Heckington Fen Solar Park

EN010123

Statement of Common Ground with Natural England

Document Reference: 7.6i

Drawing file: EN010123 / EN010123-000554-6.3.8.12 - Appendix 8.12 - Biodiversity Net Gain Calculation - Rev 2.pdf

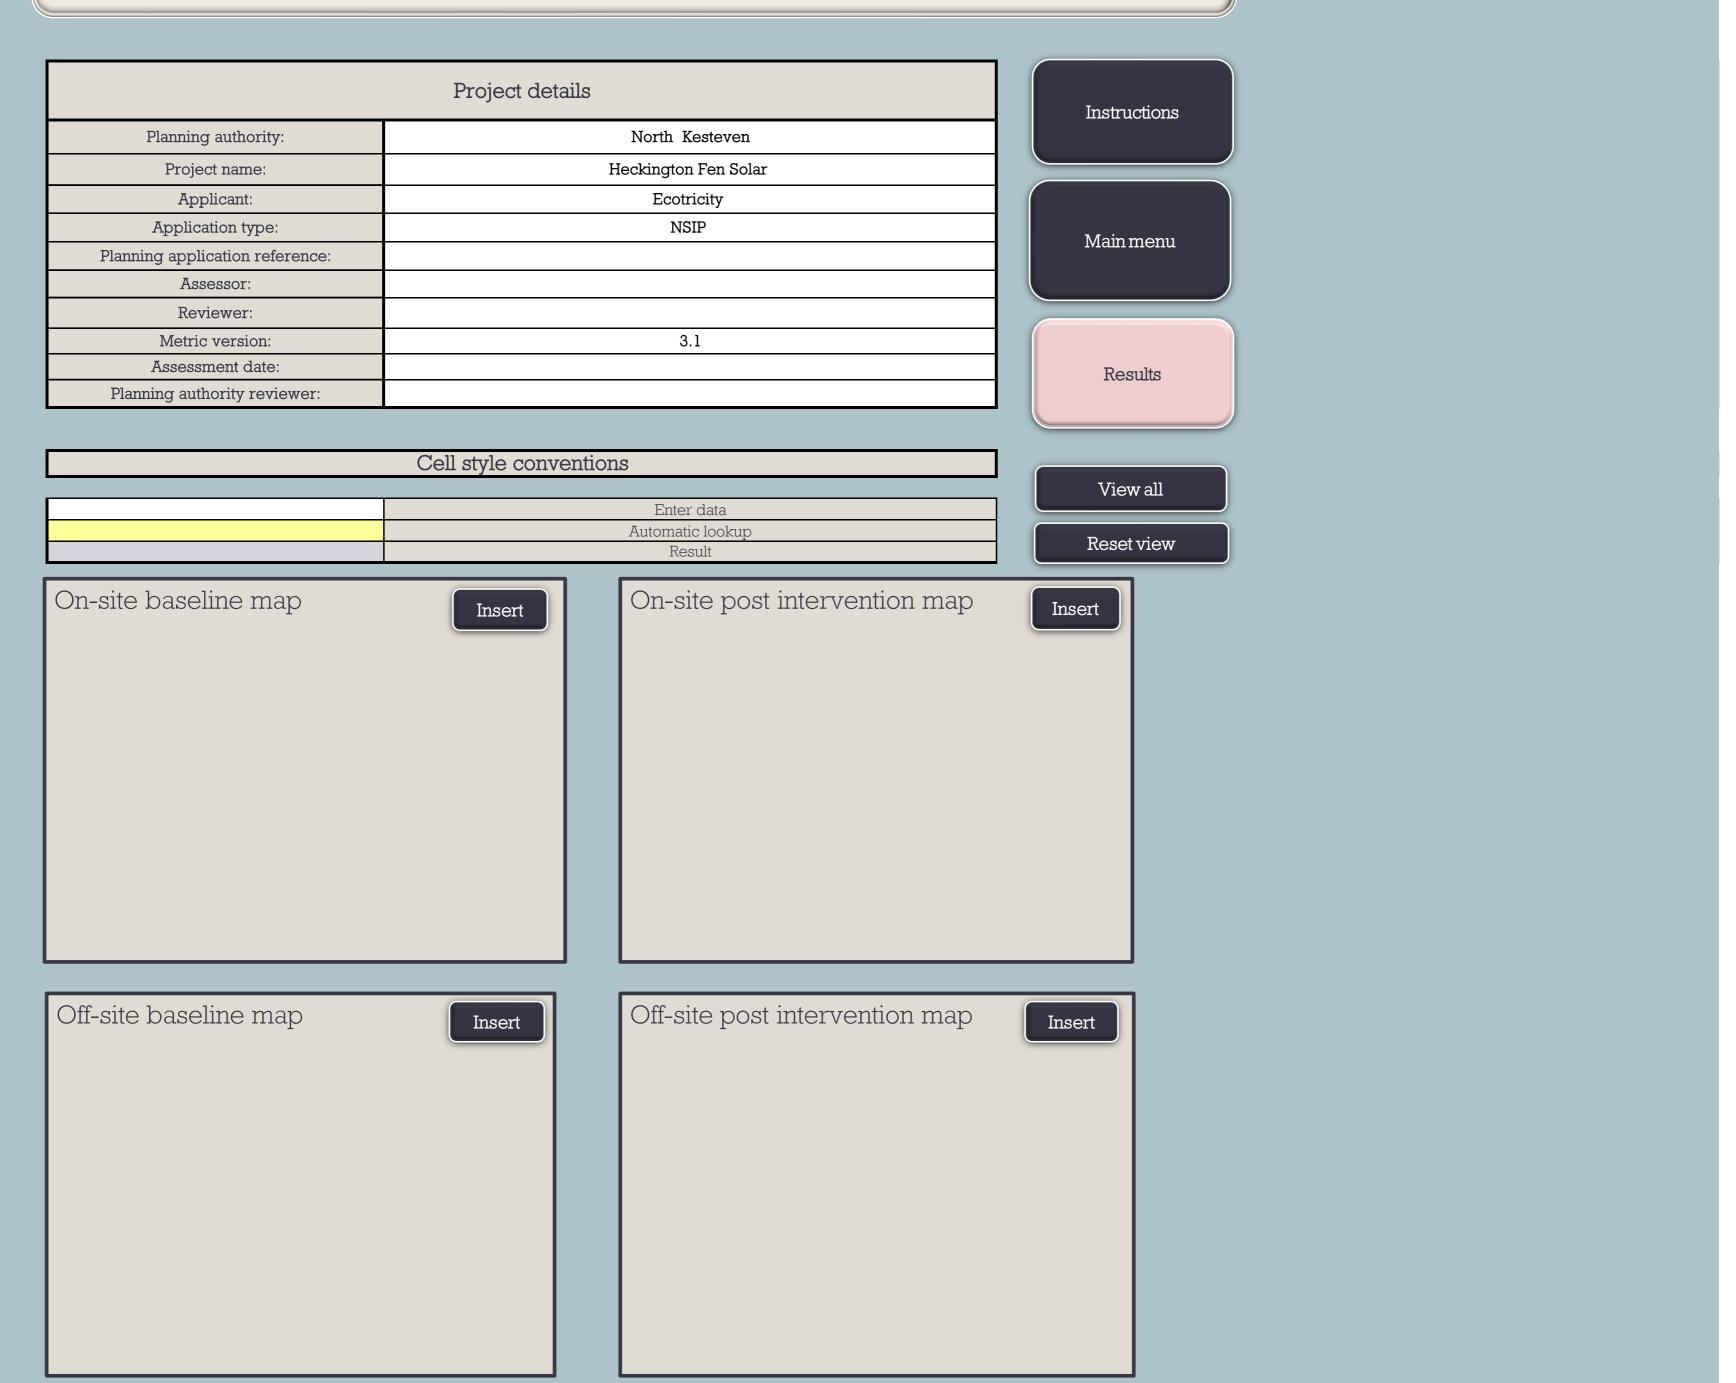
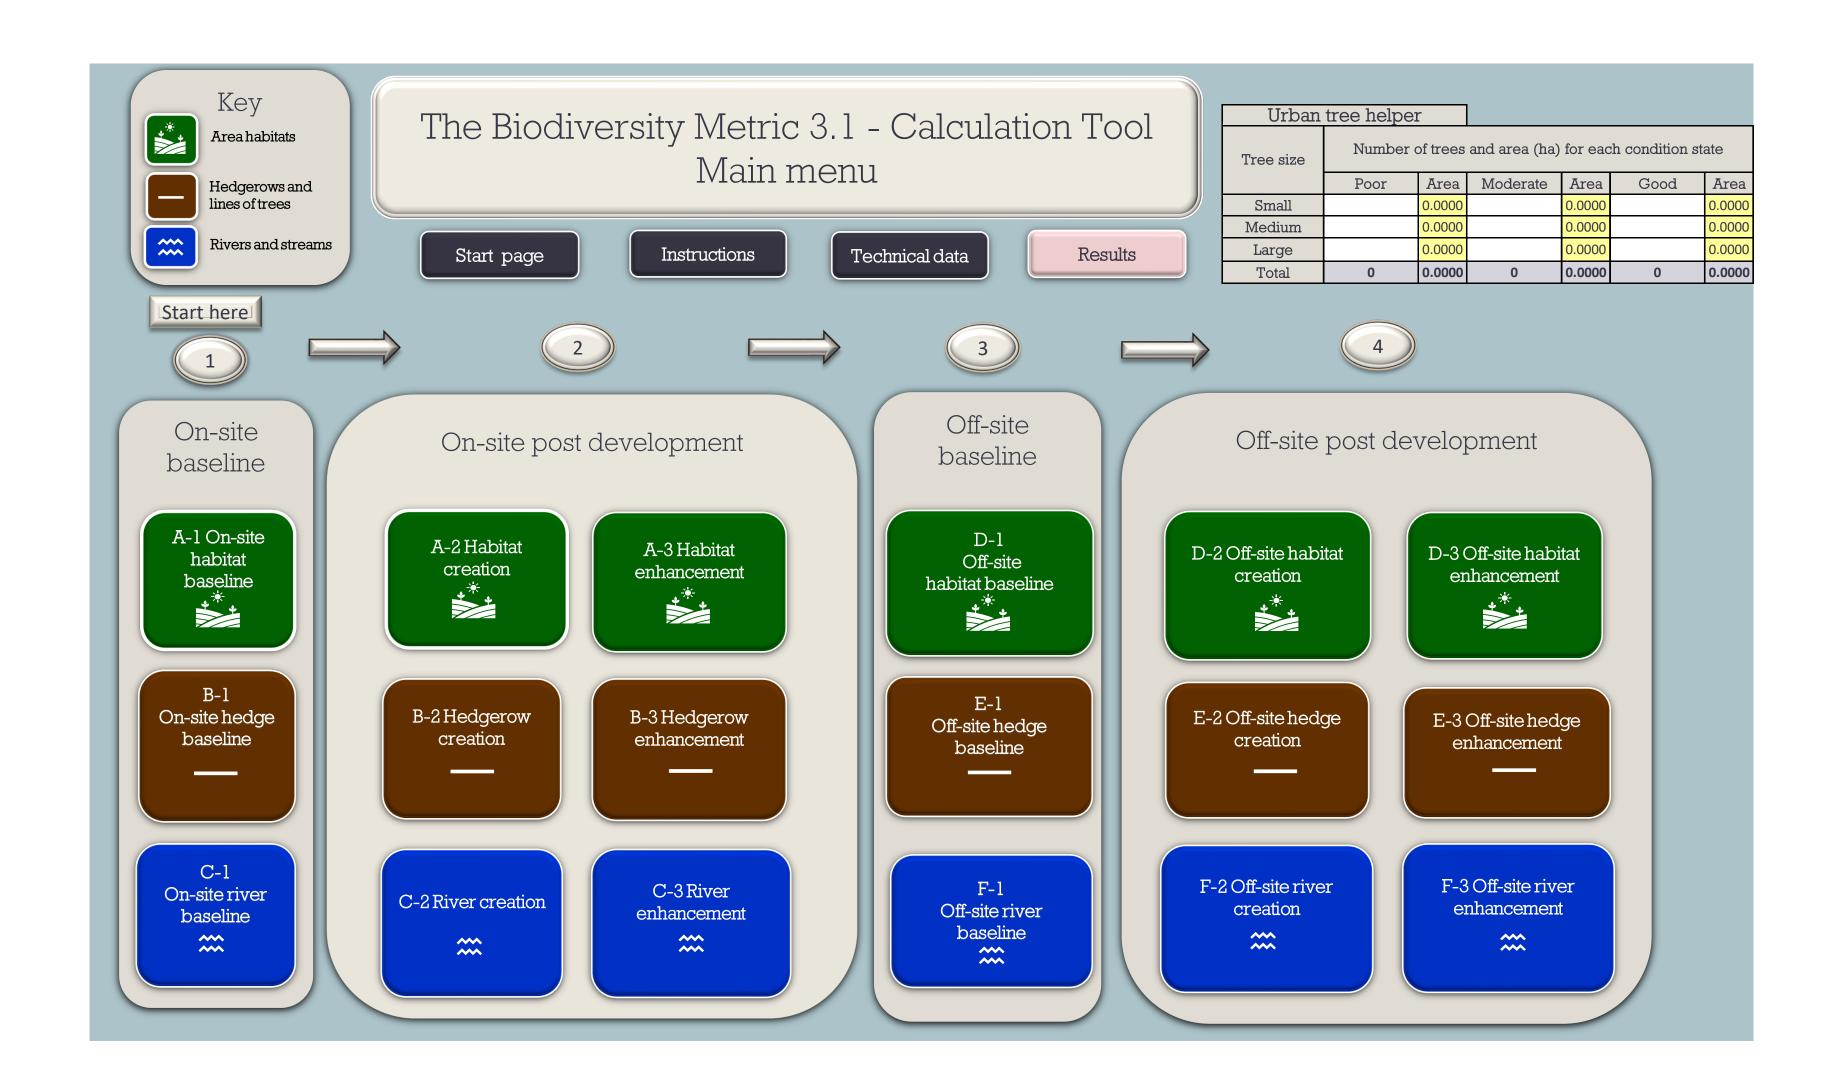
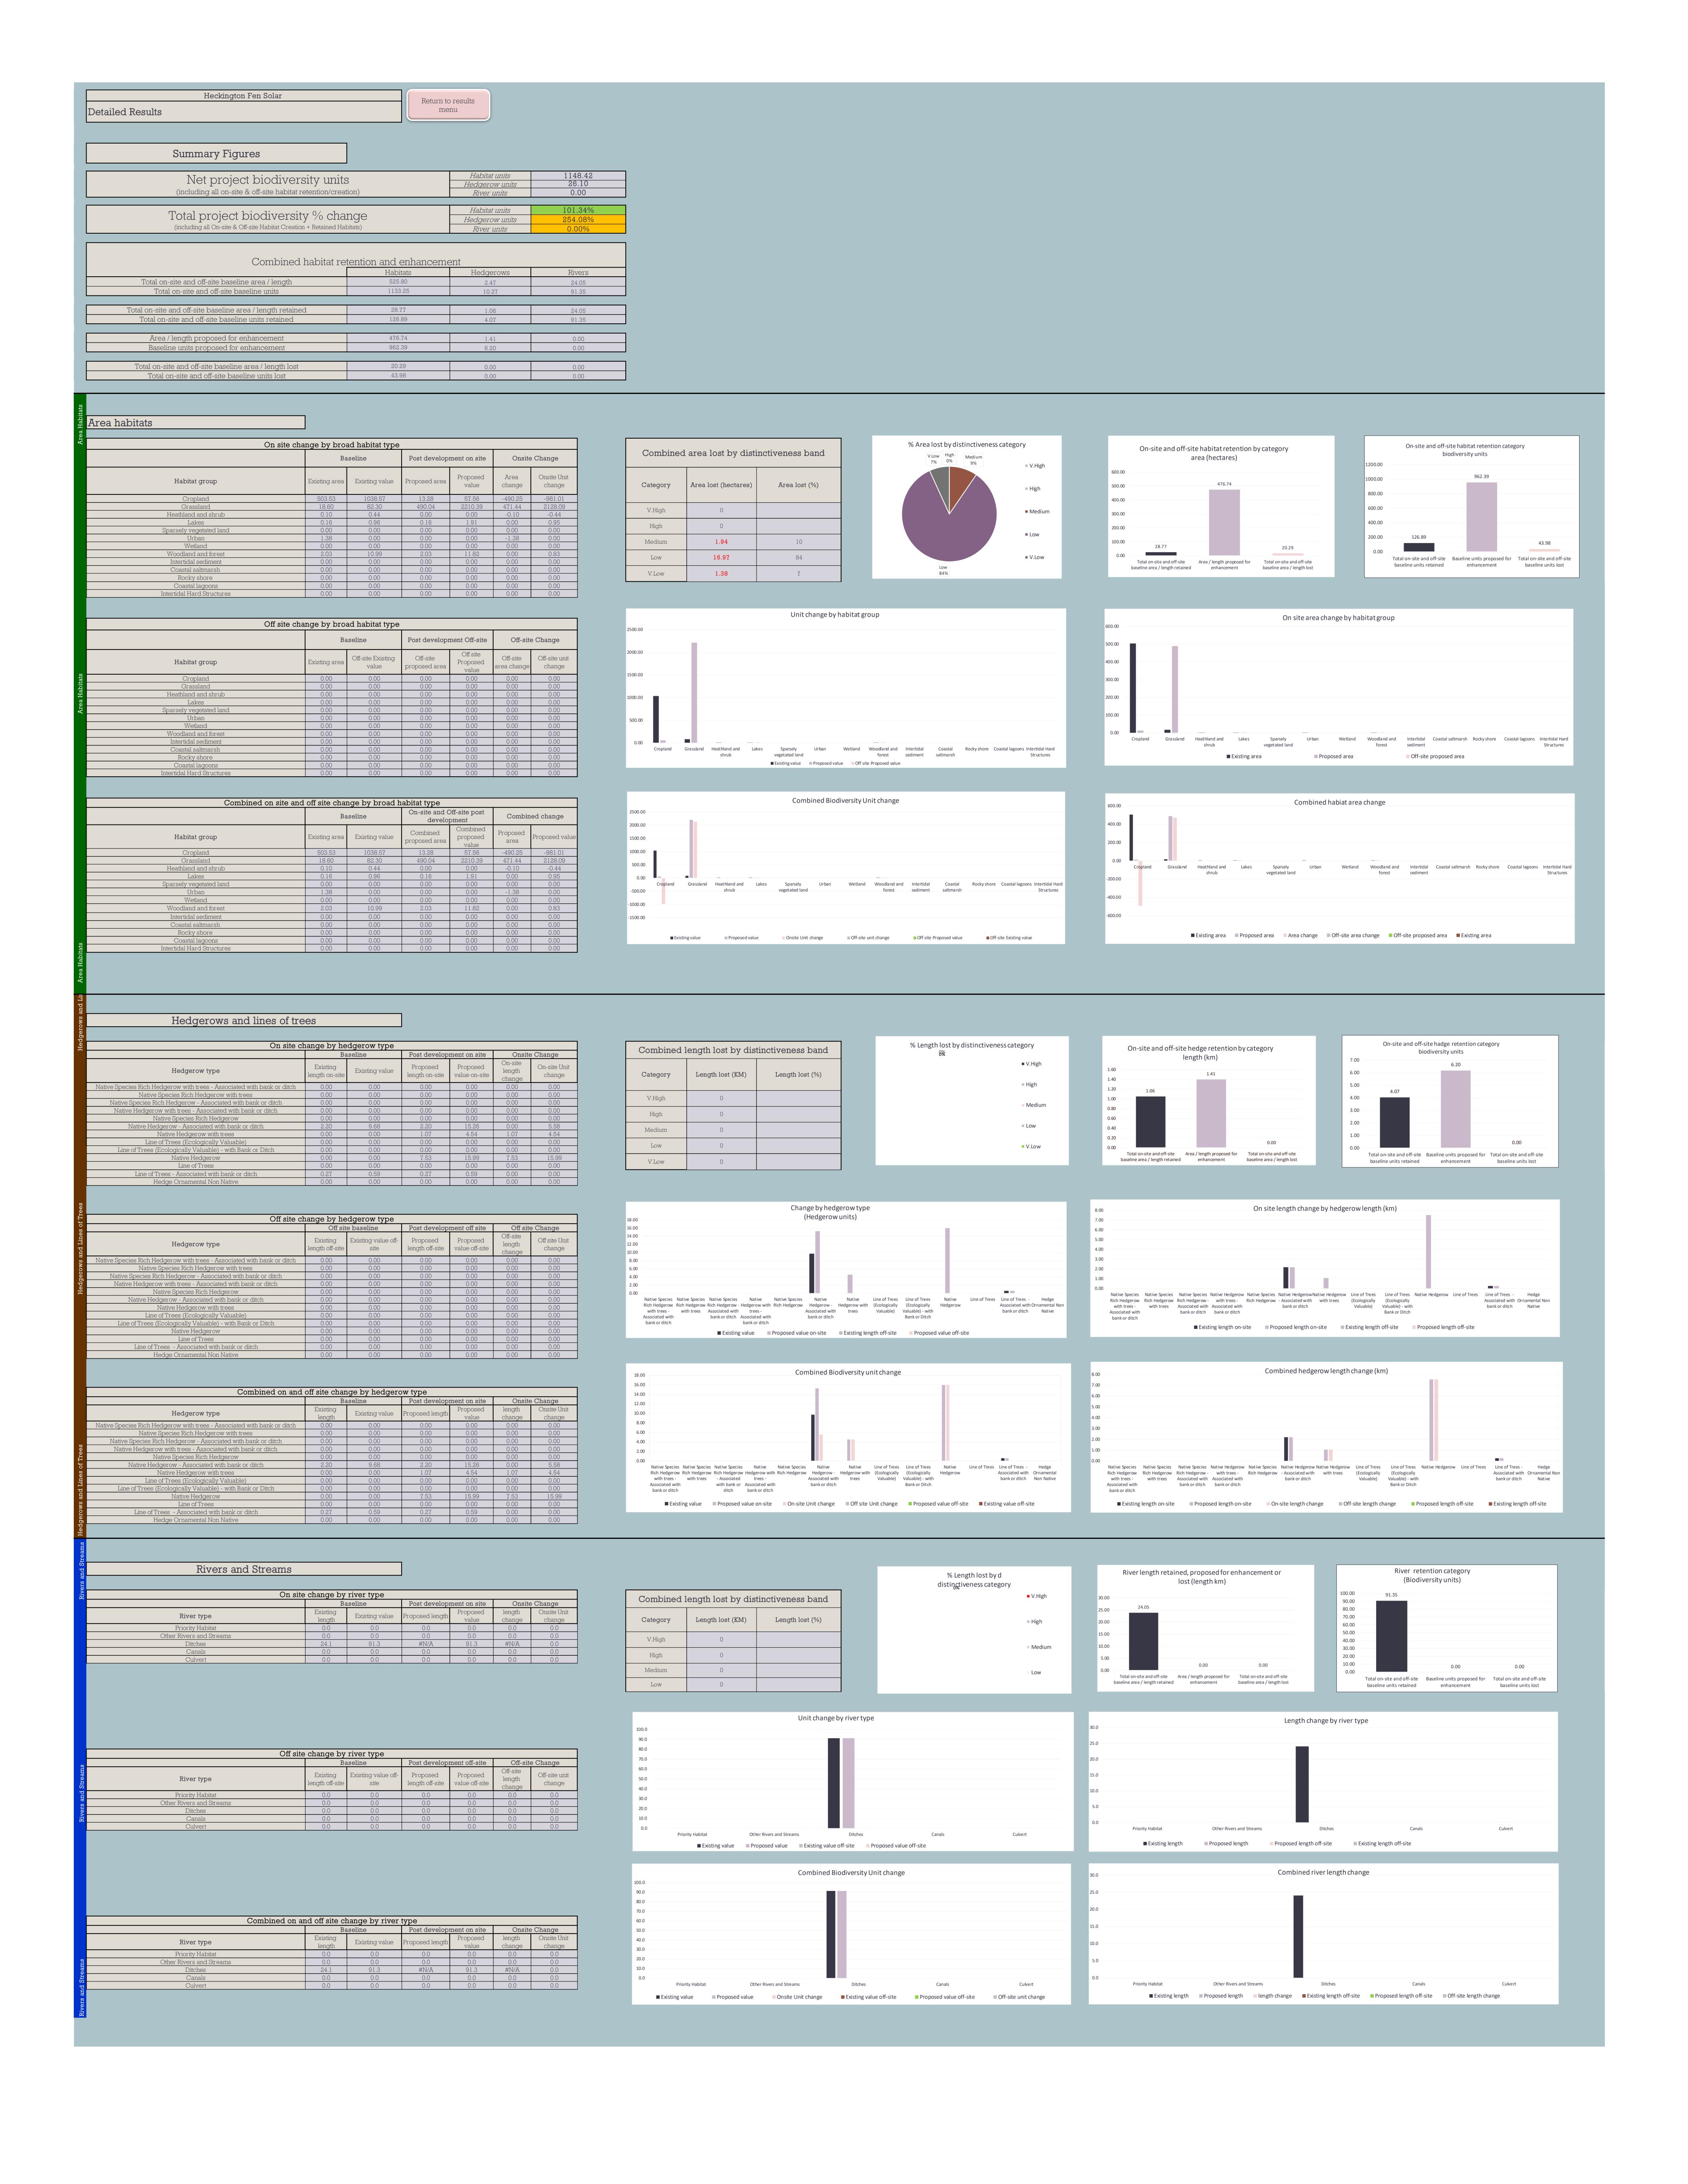
Reference and Status	Topic	NE's Position	Applicant's Position
6. Biodiversity Net Gain			
6.1 Agreed	Biodiversity Net Gain Metric 3.1 used (Appendix 8.12) provided to NE on 20 th June 2023.	NE welcomes the commitment to deliver BNG and is generally supportive of the enhancements proposed through the development. The enhancements detailed within the oLEMP, are welcomed and are likely to indirectly have a positive effect.	The Applicant notes NE's comments made in relation to BNG during consultation which are generally supportive of the enhancements proposed, and detailed in the oLEMP.
